**Consultation Response from KC,
Highways Development Management****2024/93474 35, St John's Rd, Birkby, Huddersfield, HD1 5DX****Change of use from vacant industrial unit to 21 flats / maisonettes including partial demolition and new build****Date Responded: 23/05/2025****Responding Officer: Ryan Kinder****Responding Ref: K5-8NW-23**

2024/93474 35 St Johns Road, Birkby.

RECOMMENDATION: Objection due to lack of off street parking (associated with the 3 bed units).**Development Overview:**

client	MR H CHAHAL		
project	RESIDENTIAL DEVELOPMENT 35 ST JOHNS ROAD BIRKBY HUDDERSFIELD HD1 5DX		
drawing	PROPOSED FLOOR PLANS		
revision	notes	date	drawn
scale :	1:100 AT A1	11.24	PB
project no.	2327	drawing no.	03

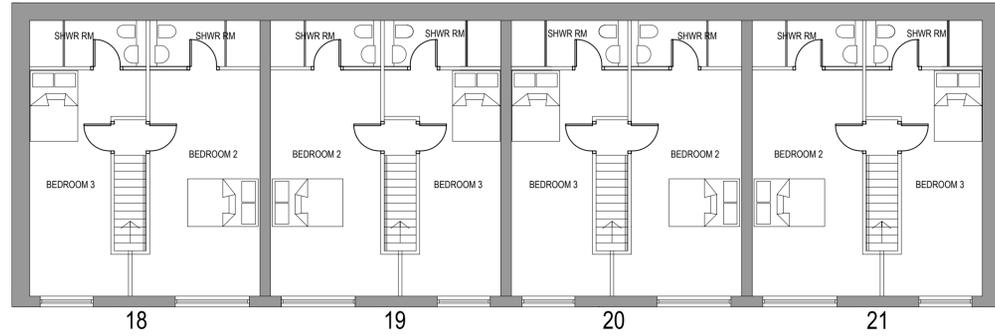
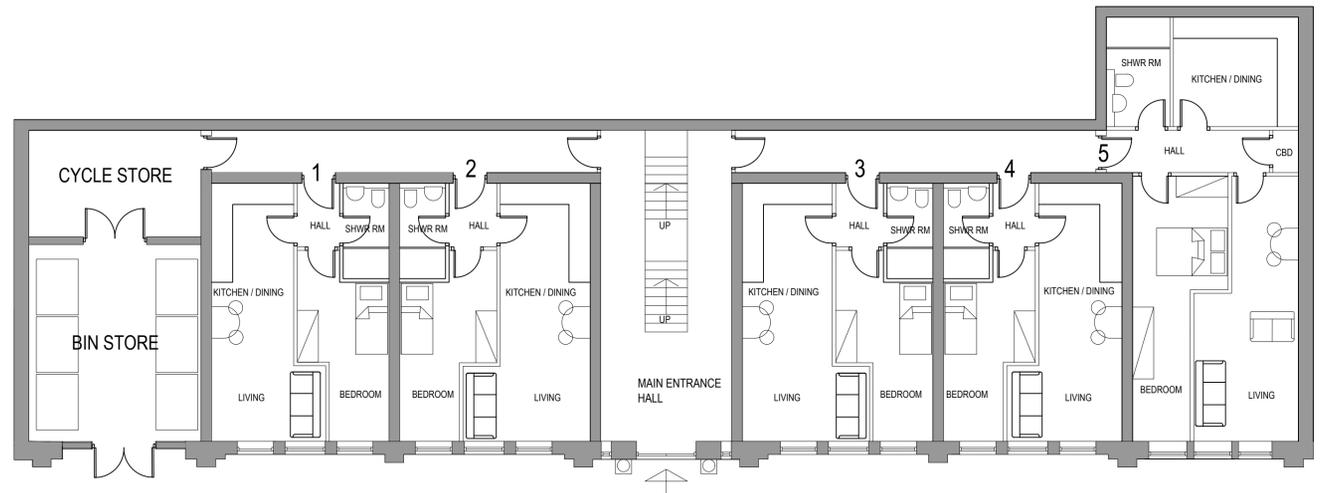
The proposal to accommodate 17 no 1 bed units and 4 no 3 bed units. No off street parking is provided for the development. Whilst it is acknowledged that the development is considered to be in a fairly sustainable location being close to Huddersfield Town Centre and generally no parking provision for 1 bed units would be accepted, there are concerns regarding the lack of off street parking for the proposed 3 bed units in particular given the existing on street parking situation on St Johns Road. The Council's SPD Highway design guide suggests that off street parking for 3 bed units should be at a ratio of 2 spaces per dwelling.

There are concerns regarding the lack of off street parking for the 3 bed units, HDM raise an objection with the proposal in its current form.
